**Project Metrolink Railway Order  
Estuary to Charlemont via Dublin Airport  
(ABP-314724-22)**

Statement of Evidence

Tunnelling Induced Ground Movements & Building Damage Assessment for the  
**Cadenza Building**, Earlsfort Terrace, Dublin 2

21<sup>st</sup> March, 2024

ML1-JAI-RTA-ROUT_XX-DR-Y-01027

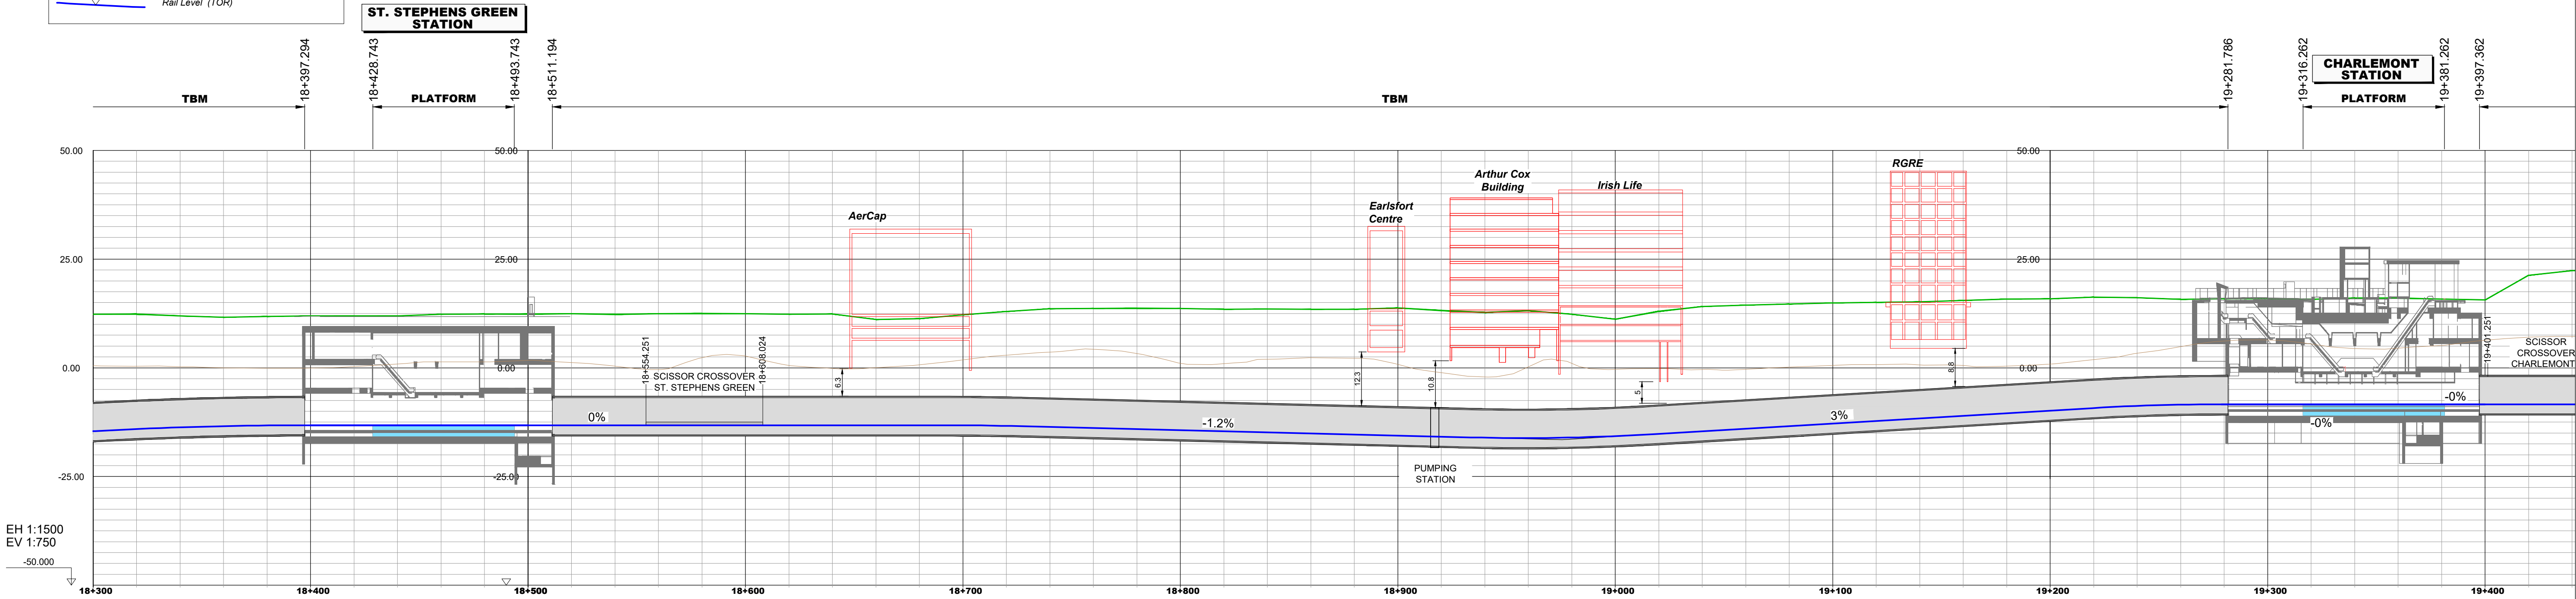
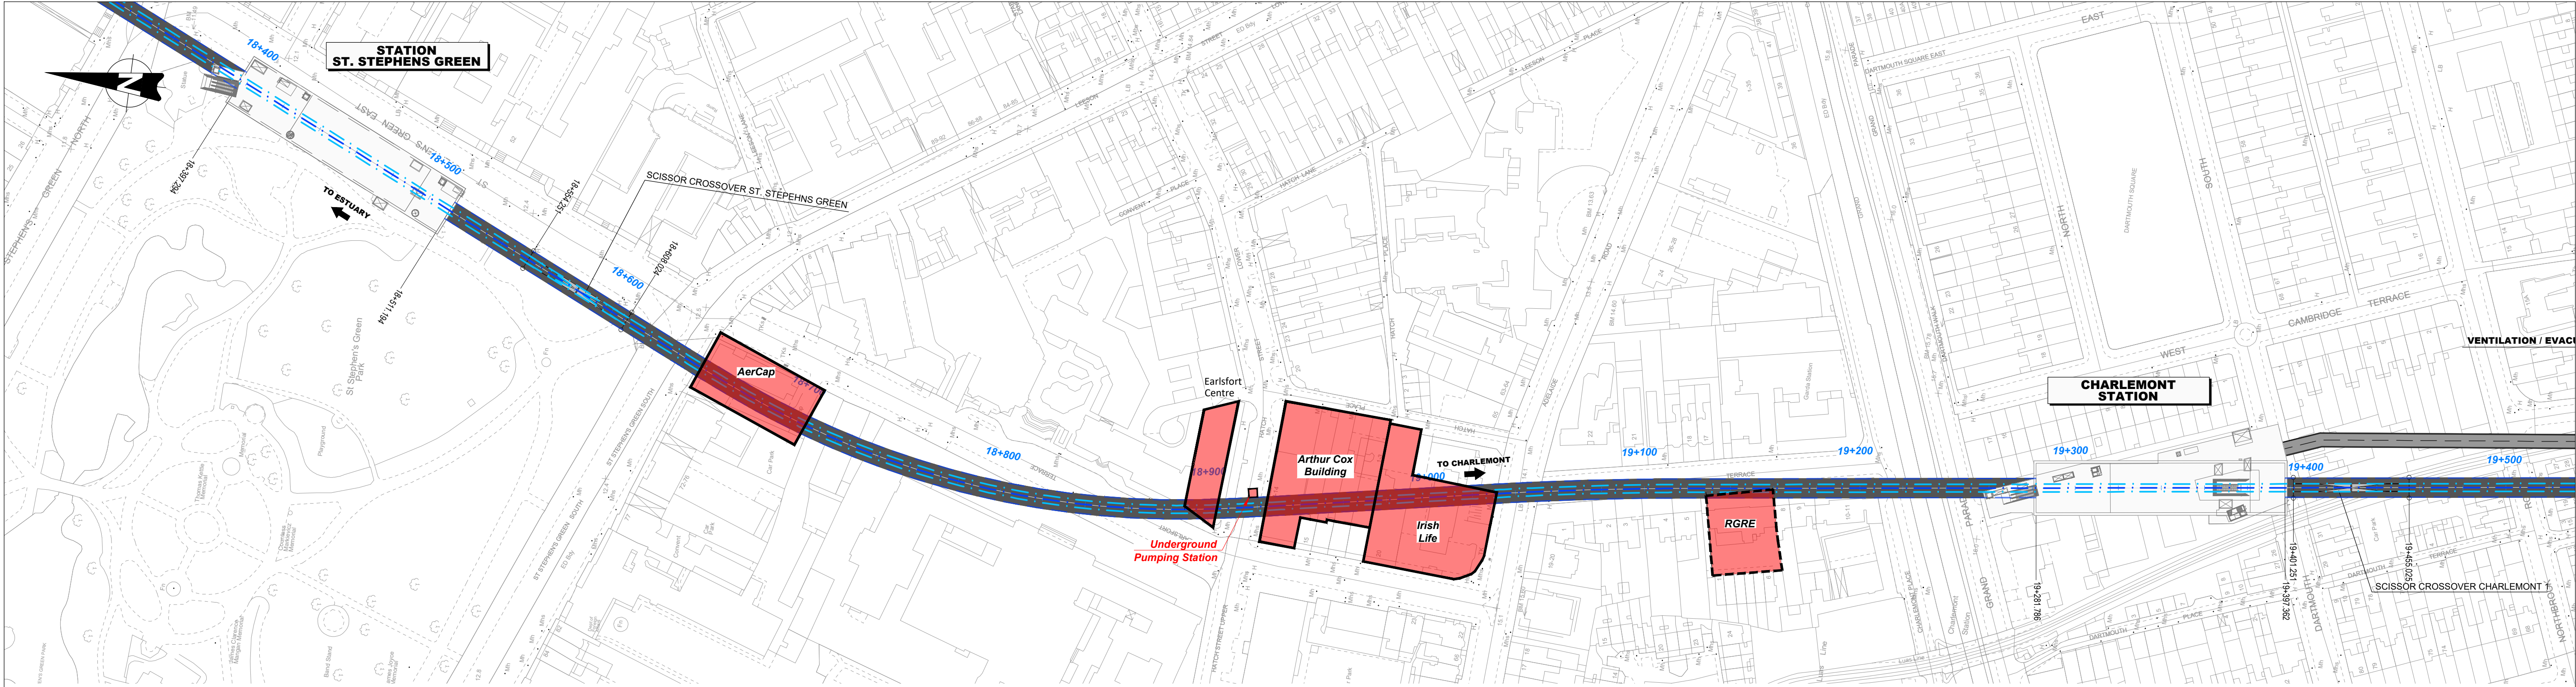
- Drawing No. ML1-JAI-RTA-ROUT\_XX-DR-Y-01027 (Rev.P02)
- Lowered tunnel alignment below Arthur Cox & Cadenza Buildings
- Avoids Anti-Flotation Anchors
- Increased Clearance below secant pile wall and foundations (10-15m)
- EIAR Addendum does not state that proposed LoD apply at this level and that upward LoD of +1.0m from this level will not be implemented.
- Stated at Oral Hearing (4/3/2024)
